From: Will Bowerman [REDACTED]
Sent: 06 October 2017 19:52
To: Zac Denton
Subject: Re: FP/199/17/T

I have just received Arboricultural comments regarding your application for tree surgery at 6 Ceres Place, Felpham.

ARUN DISTRICT COUNCIL FP/199/17/T

Garden of 6 Ceres Place.

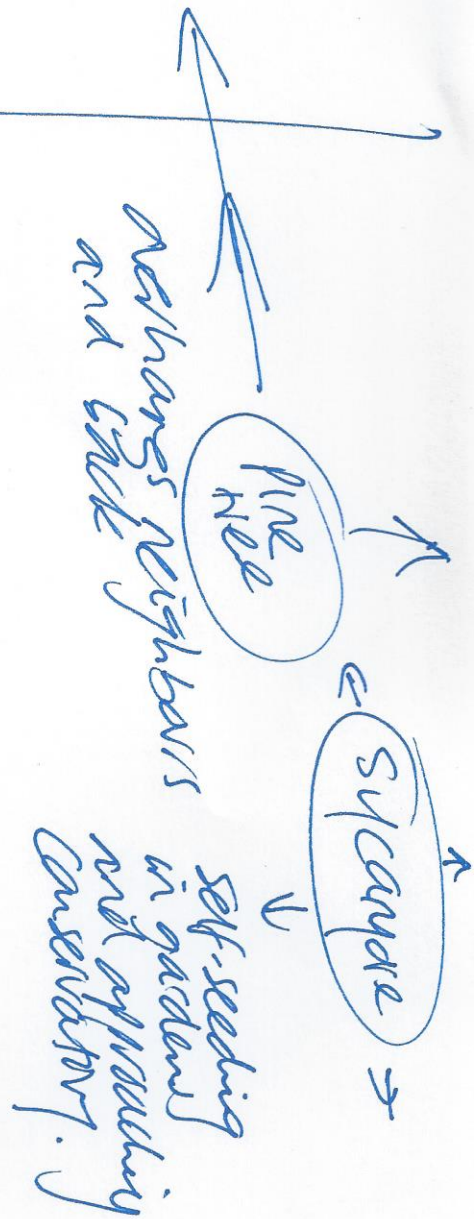
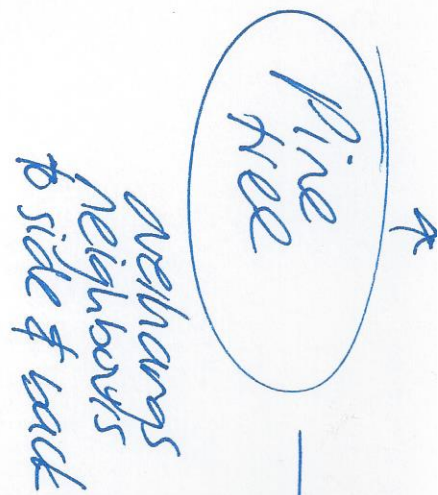
As it stands the application is set to be refused as the tree officer believes that the reduction of the pine trees is totally unacceptable.

If the reduction of the pines trees was removed from the proposal, then the application would be able to be approved. (As it would only related to the felling of the Sycamore which is acceptable)

'Totally unacceptable' seems ironic really but please can we remove the pines from the application and apply to get the sycamore removed ASAP.
